GRANDVIEW FILING 2 WATER AND WASTEWATER CONSTRUCTION DOCUMENTS

PCD# - PPR-24-21

D.R. HORTON - GRANDVIEW RESERVE
SANITARY SEWER LIFT STATION
DESIGN & PERMITTING SERVICES

SHEET
 C101

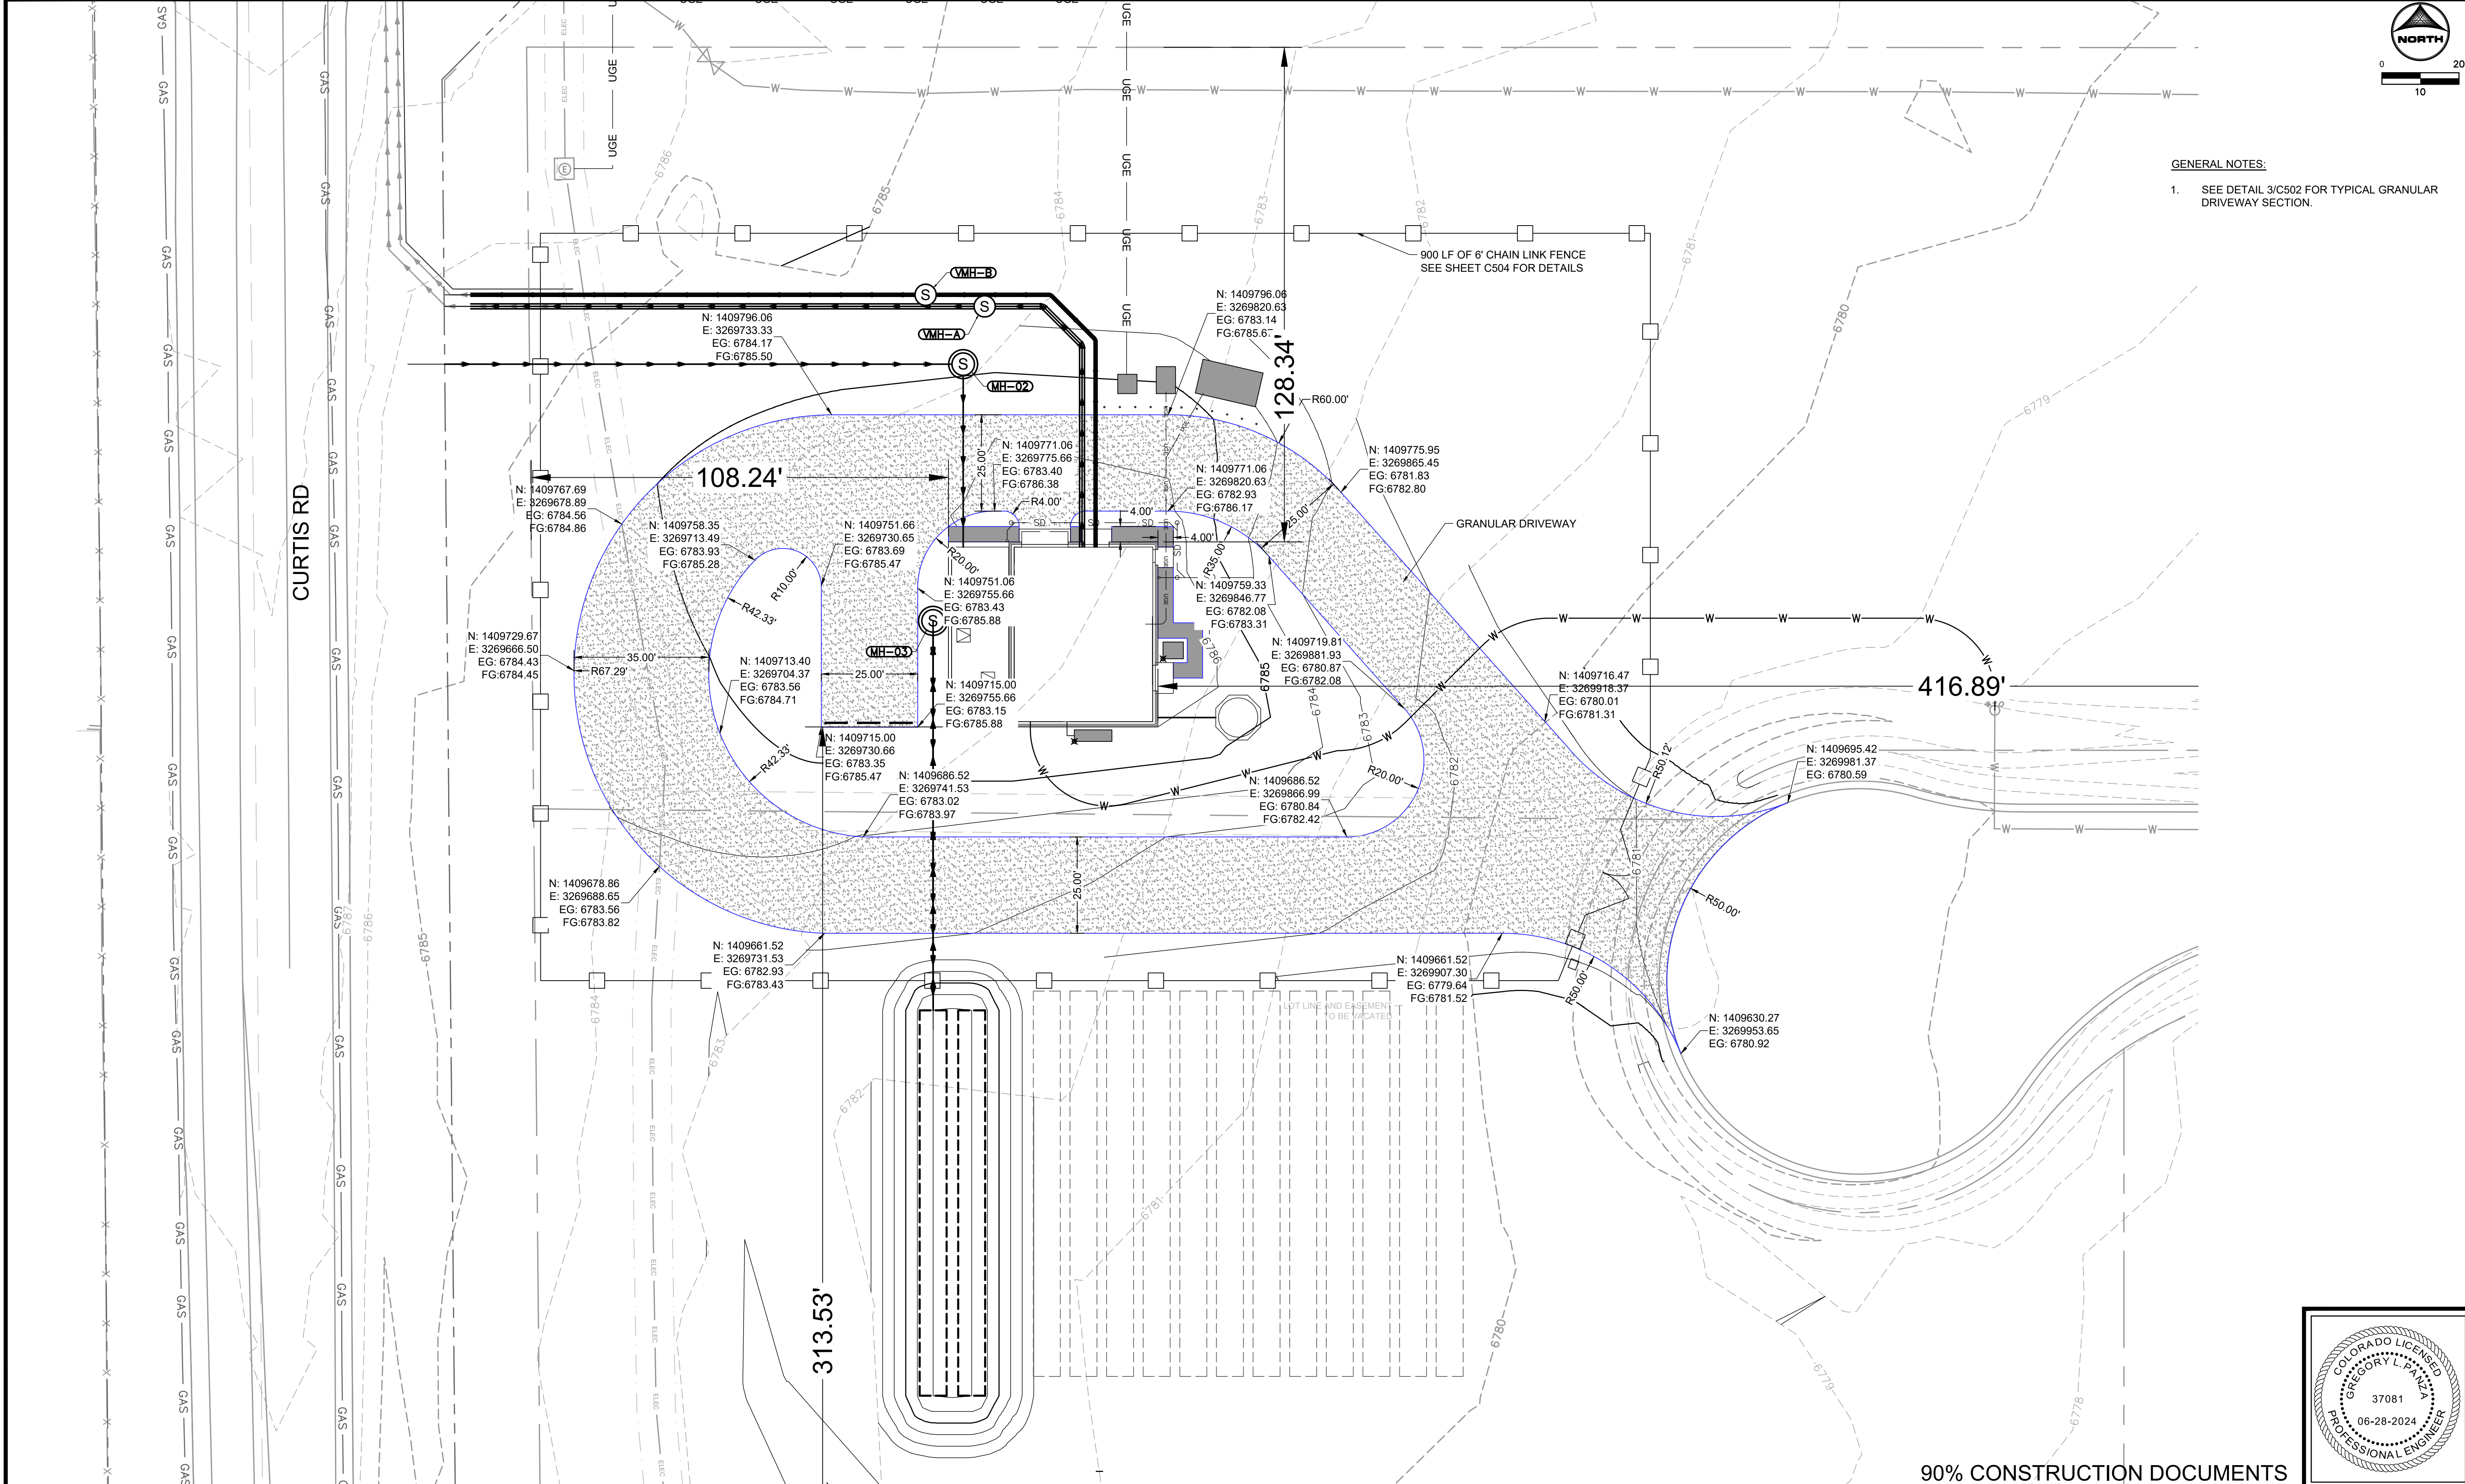
unresolved:
 where will parking be on site for maintenance crews?
 numbers 1 2 3 4 5 9 10 11 are noted but the legend does not depict what they are in reference to. Please update legend
